Honor Caird Marren

From: david myler <david.myler7@gmail.com>
Sent: Thursday 20 August 2026 14:19
To: SIDS
Subject: In relation to case no. ACP-324165-26 (Honor Caird Marren - Executive Officer)

Your letter advises that I am invited to respond to the applicant's 'Response to Observations Report' - relating 'only to section 4.3.2' of that report.

Bottom image is a detail from the Maughanaclea Ltd. Cultural Heritage Assessment mapping, **SHOWING ERROR**

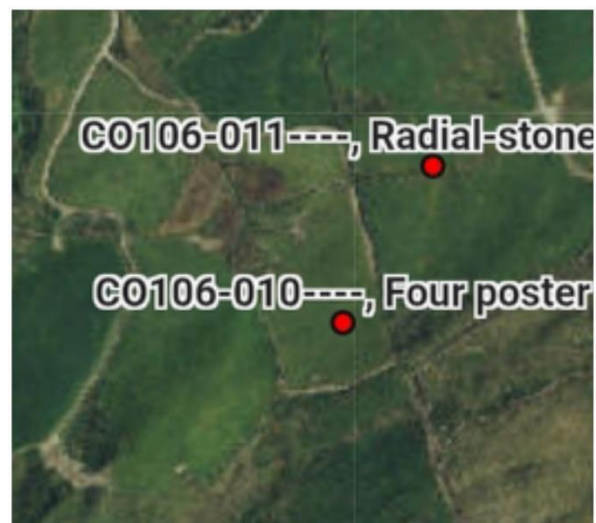
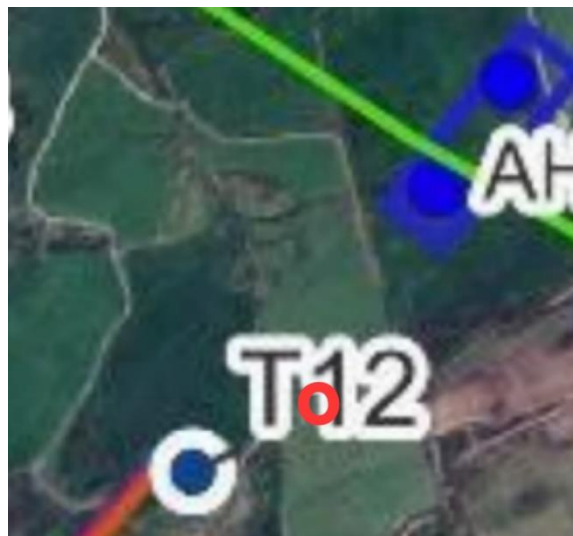
As pointed out in my observation, the submitted proposal by as it stands, has a significant mapping error. I do not see any account, acknowledgement, comment or response regarding this error on the current available documents?
